### City of Gosford Design Advisory Panel

Review item: Exhibition of State Significant Development Application – Gosford Alive (SSD-9813)

The City of Gosford Design Advisory Panel has reviewed your revised proposal for Gosford Alive at 136-148 Donnison Street, Gosford (former Market Town/Kibbleplex). A summary of the Panel's observations, advice and recommendations arising from the review is attached to this letter (**Attachment A**).

Drawing Title
ELEVATION SCHEME DONNISON

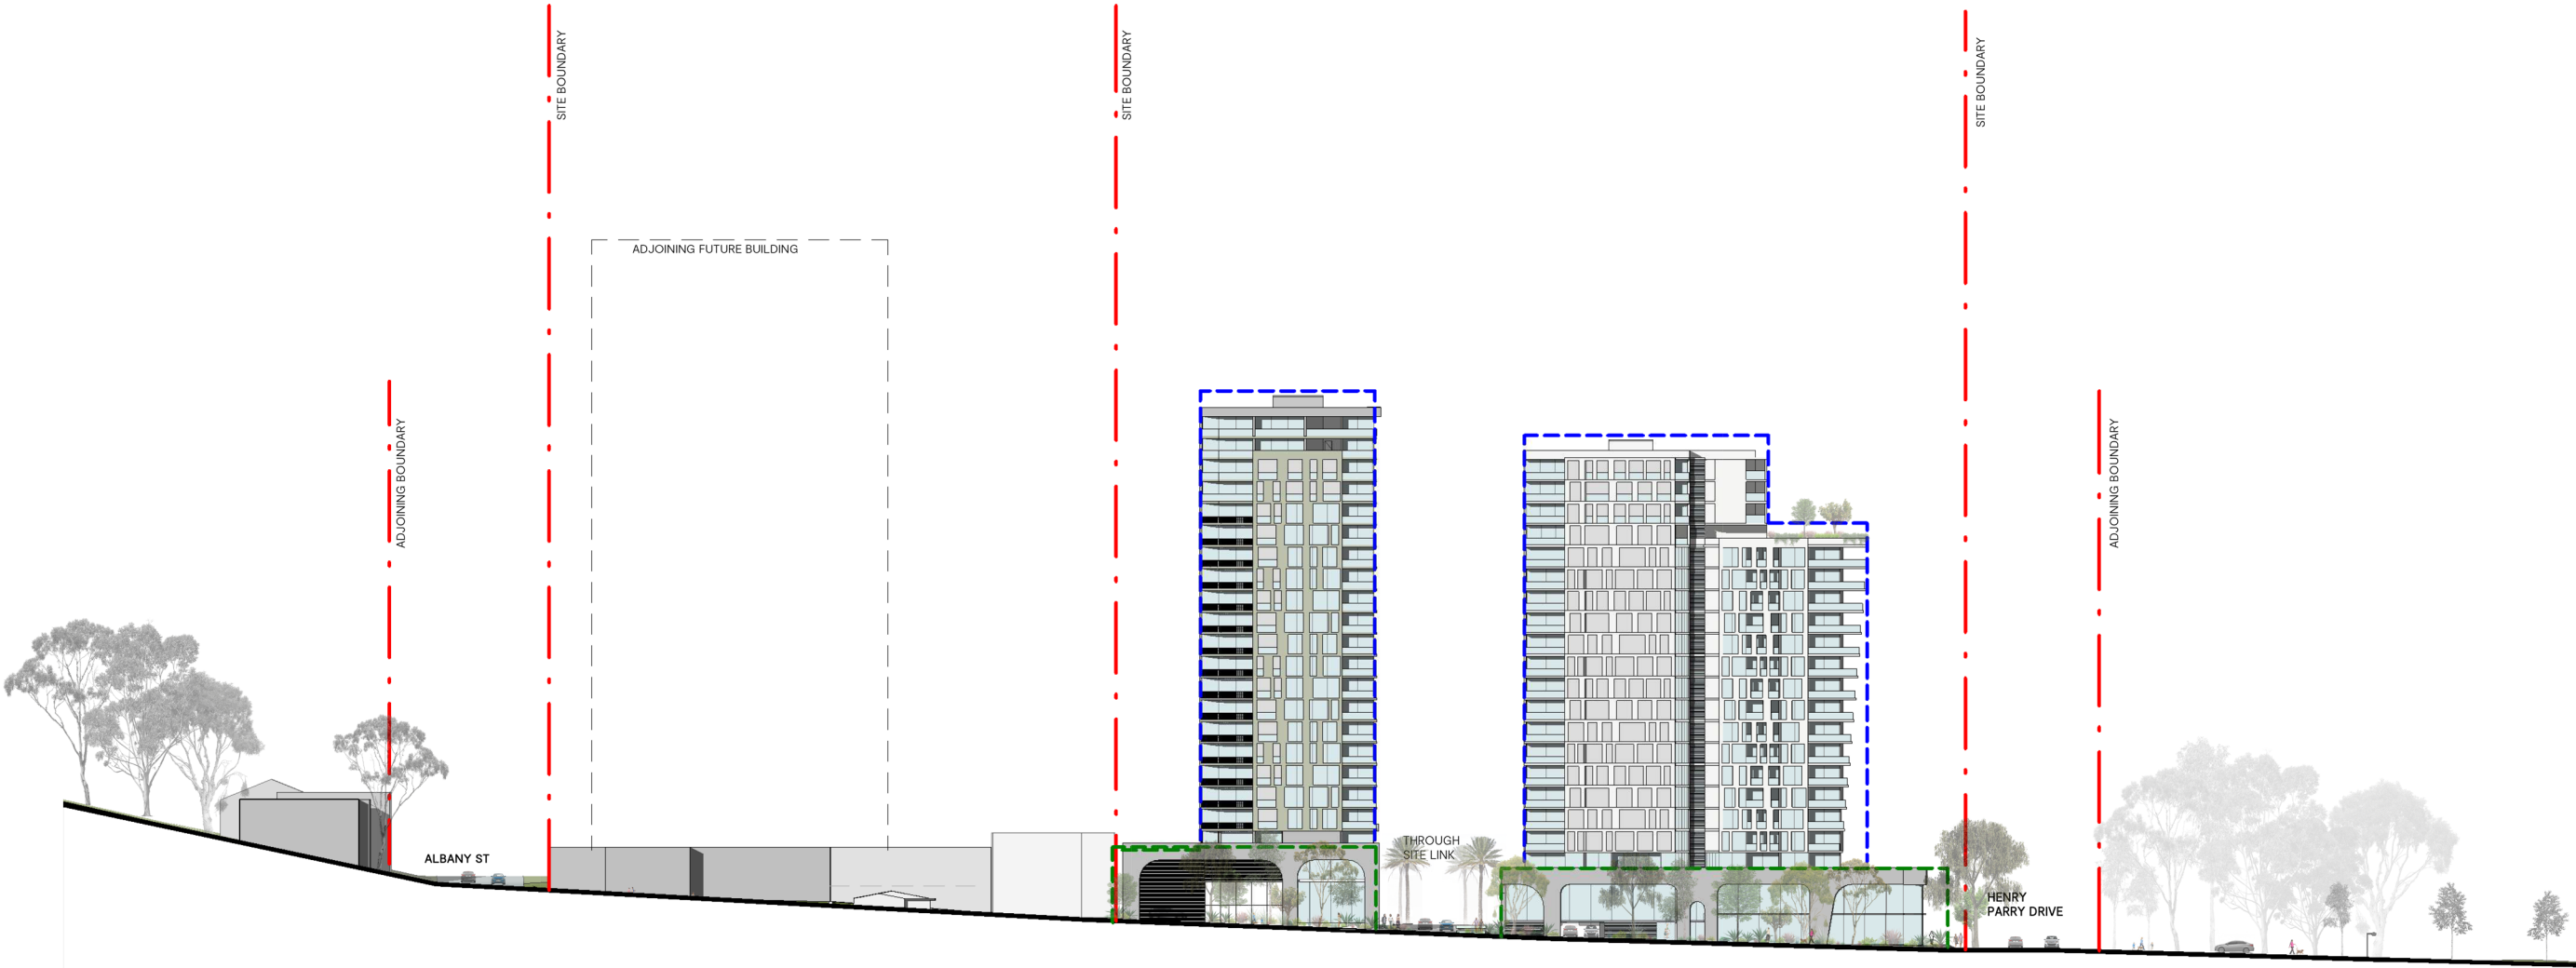
5. *The Panel recommends further refinement of the Donnison Street frontage with consideration given to further residential development, at street level, whilst appropriately screening car parking. Consideration could be given to a skin of residential development along the Donnison Street frontage.*

The Panel is satisfied that the proposed building envelopes address the requirement to screen the car parking space along Donnison Street with residential development to activate the southern elevation.

APPENDIX 1E – Shadow Diagram

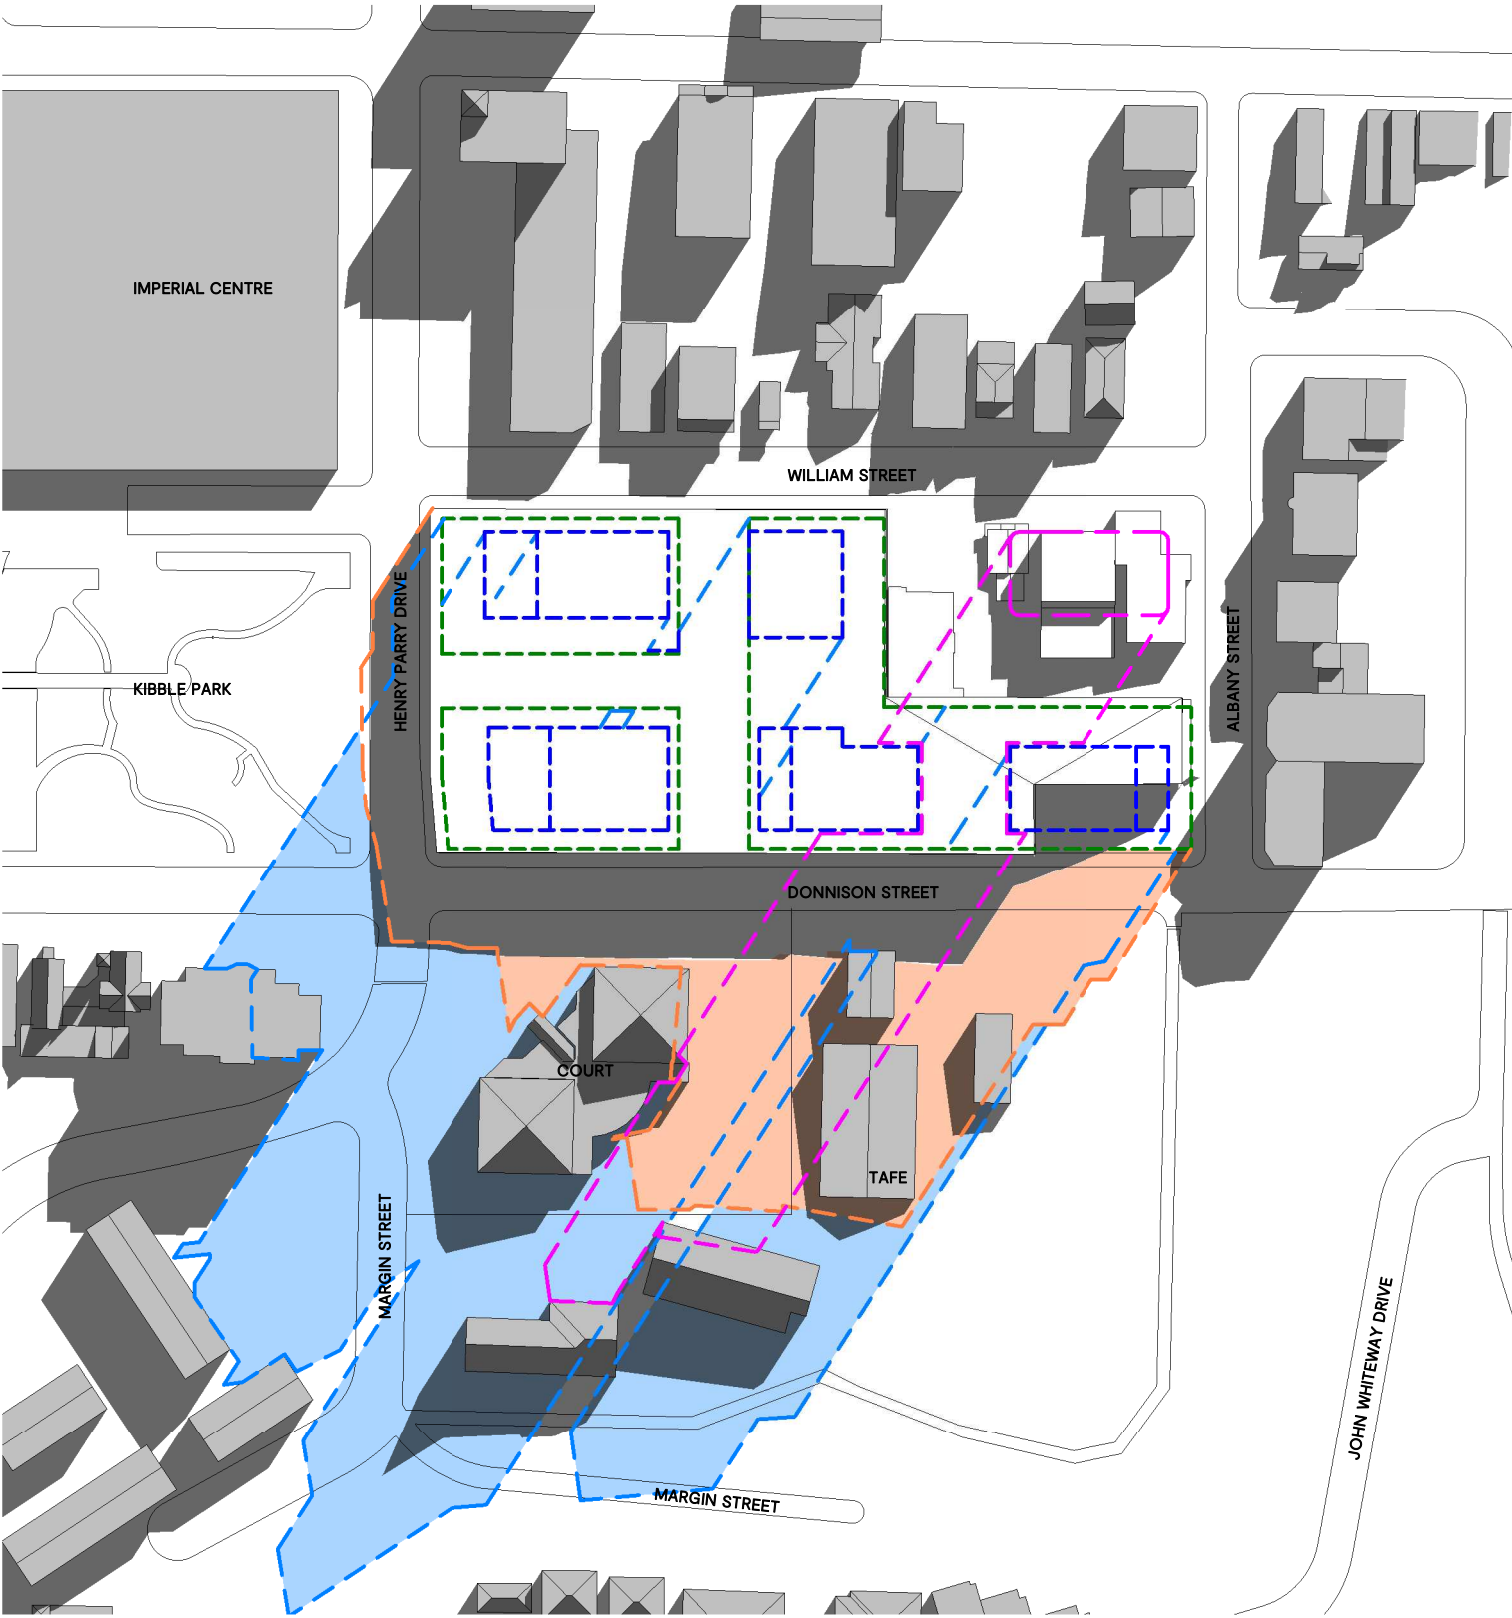
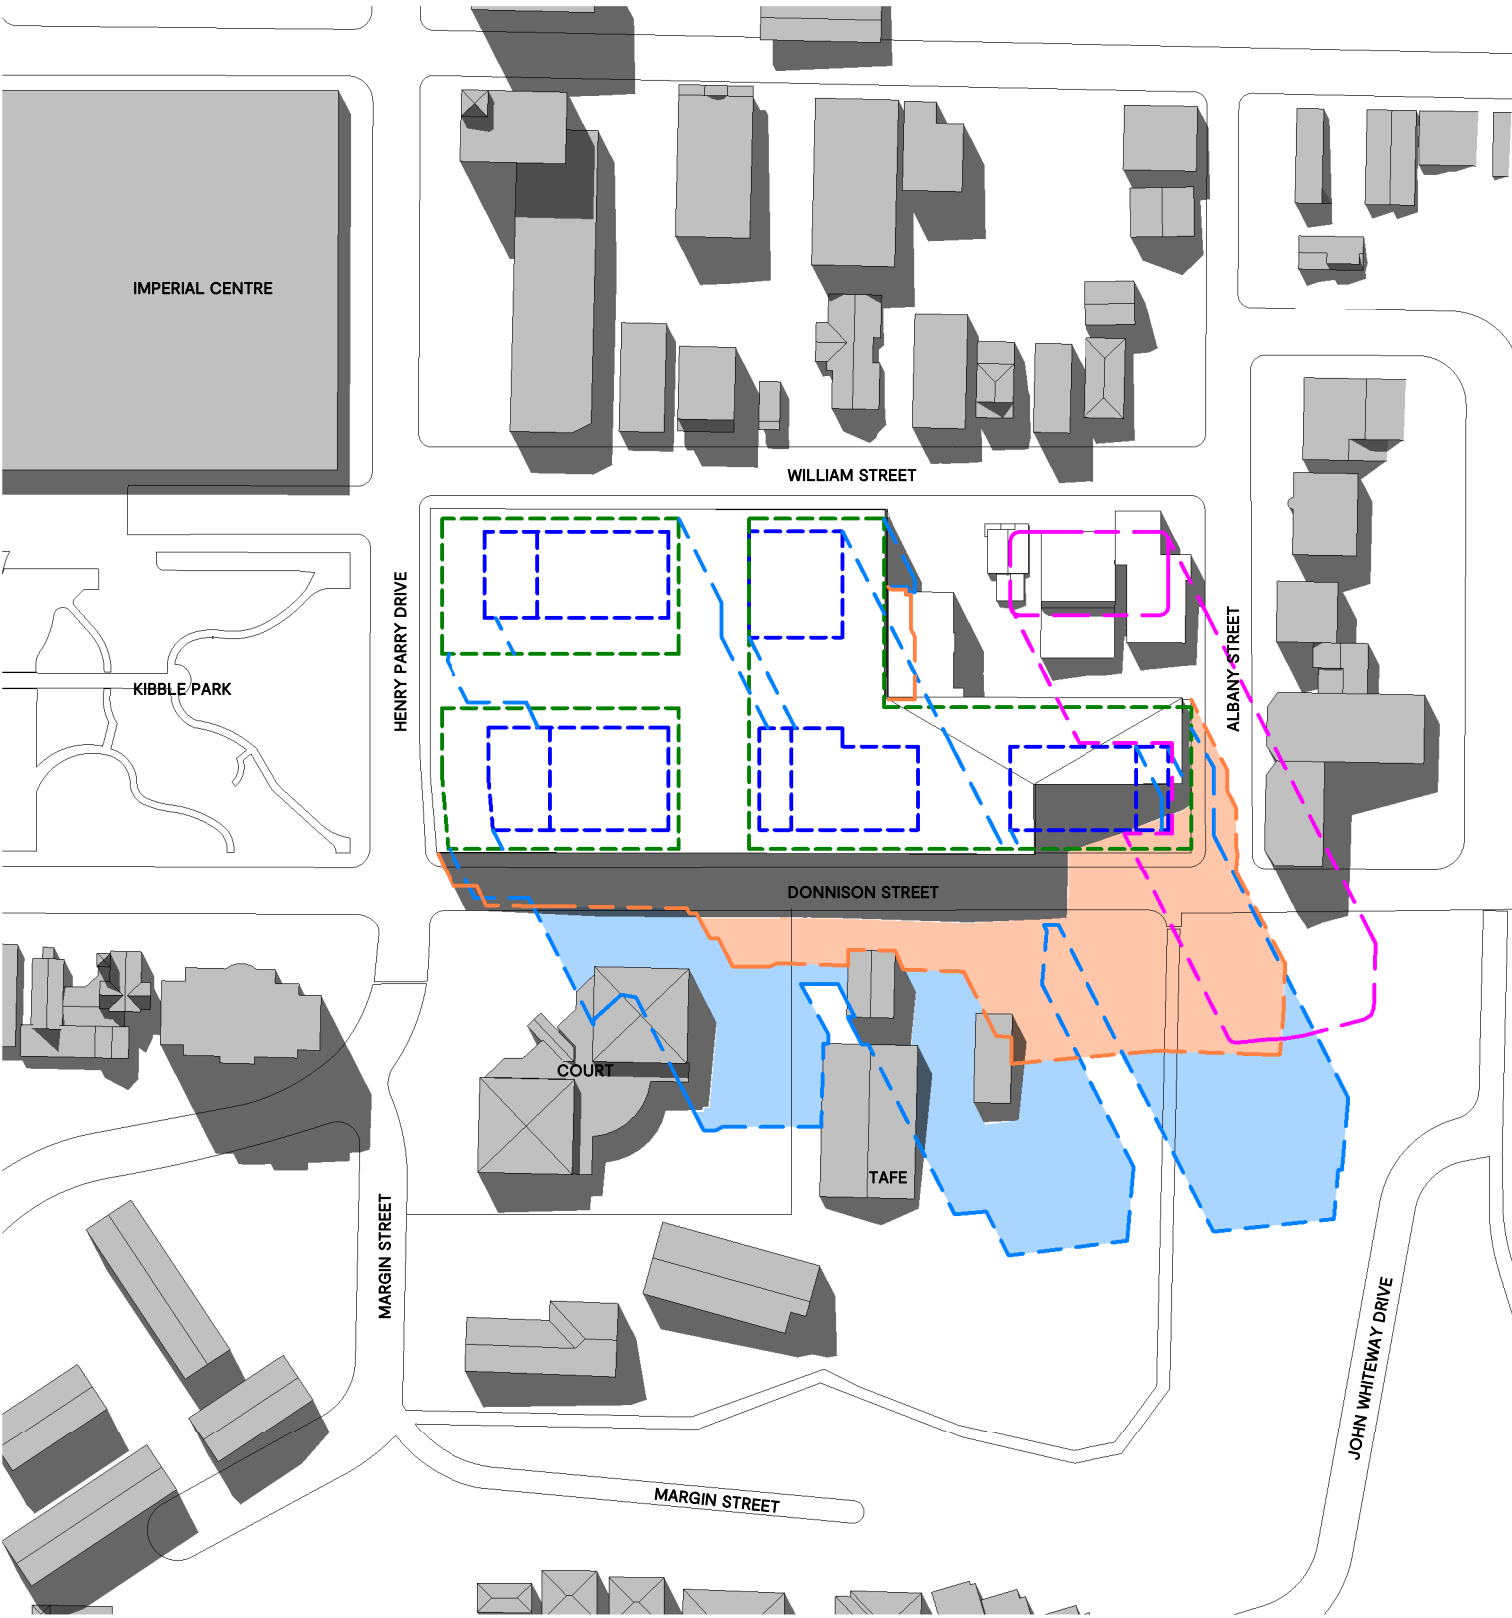
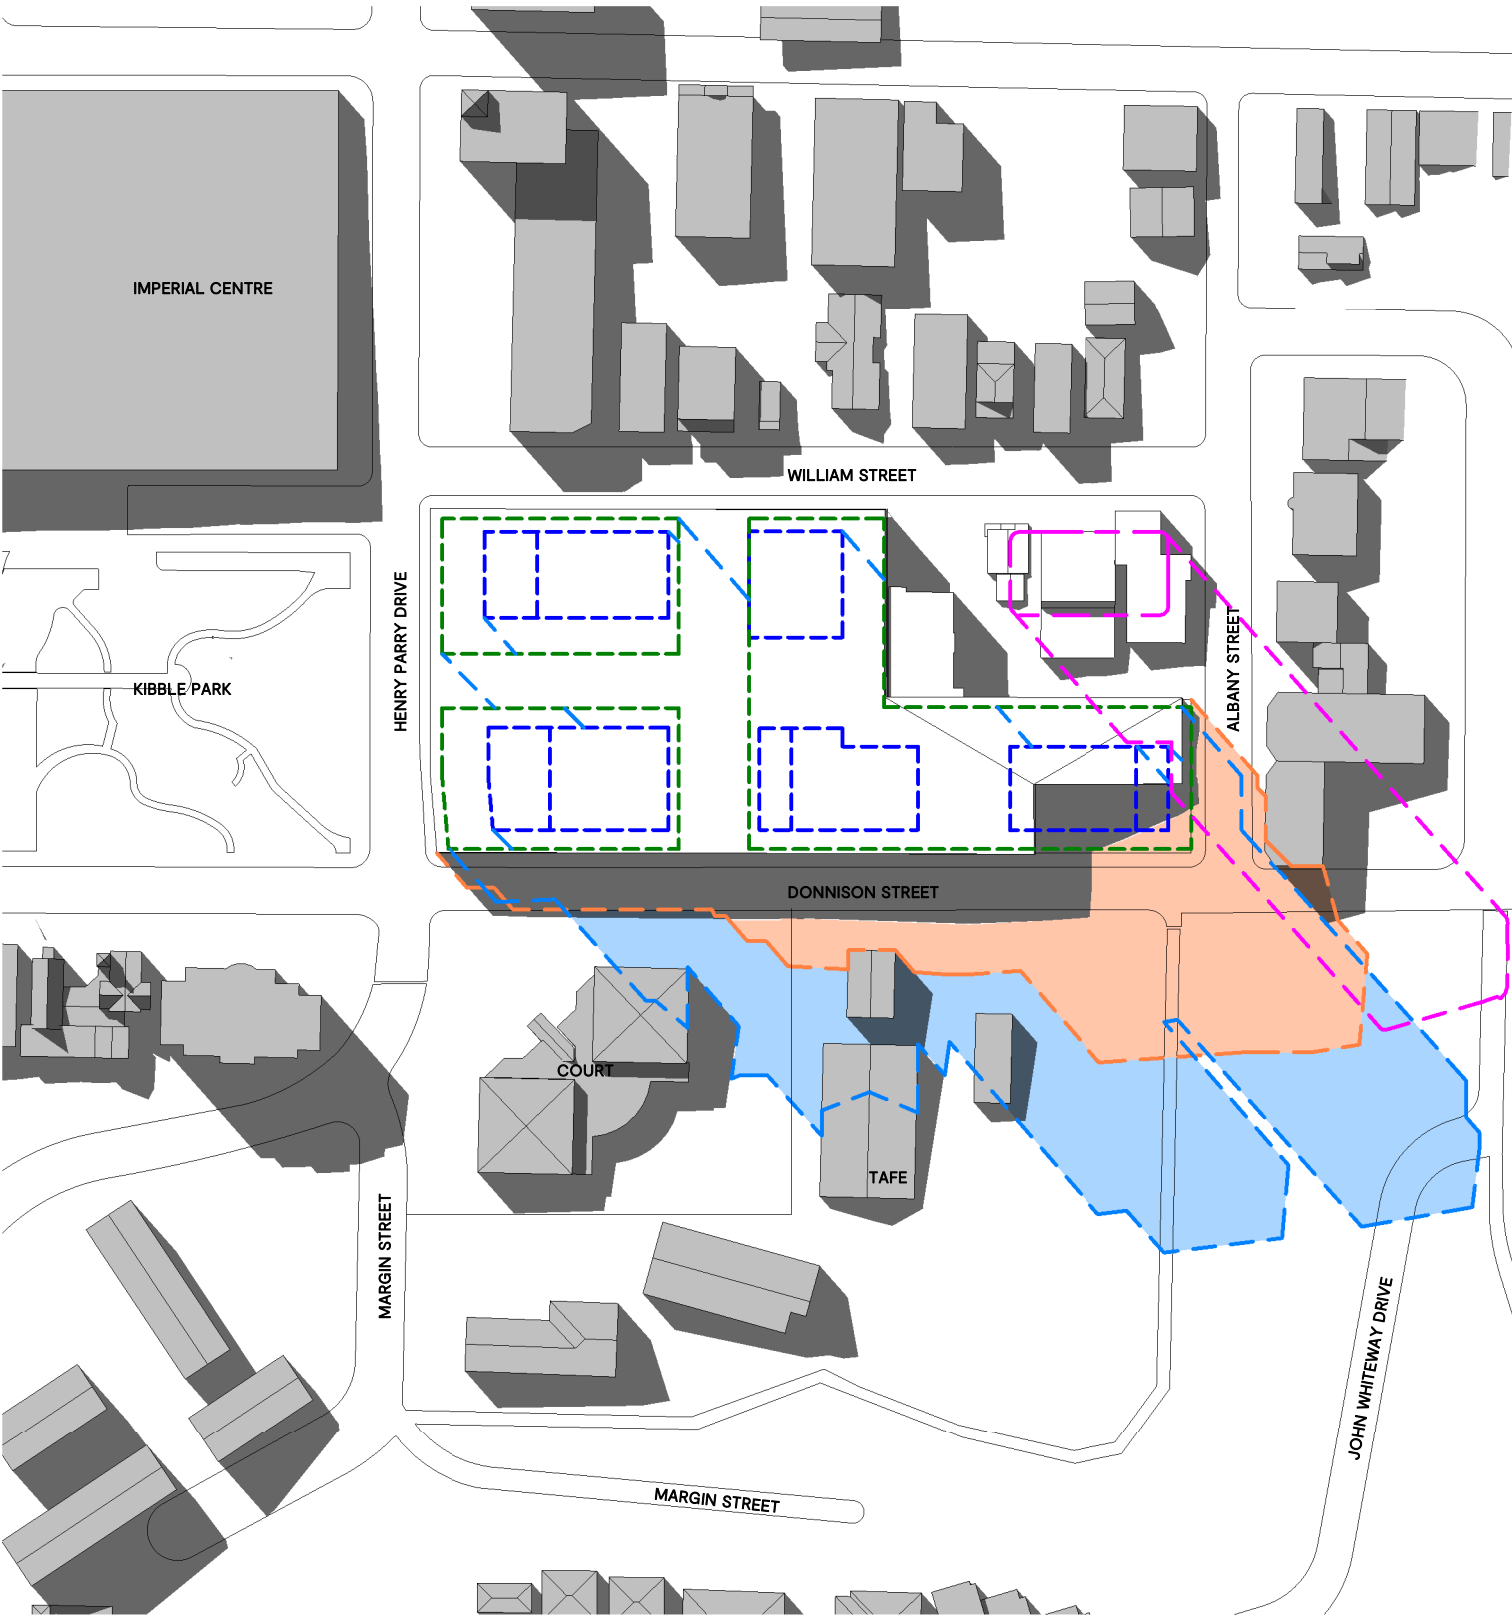
The Panel was not able to determine whether all future apartments will achieve the ADG solar access requirements for the proposed southern towers. The solar study should be updated to include the view from the sun and any shadow impacts on the proposed envelopes to allow it to be considered as part of the current assessment process. The Design Guidelines to ensure that future apartments in the development achieve, as a minimum, ADG compliance, noting the Panel's view that the proposed tower envelopes, from an urban design perspective, are acceptable.
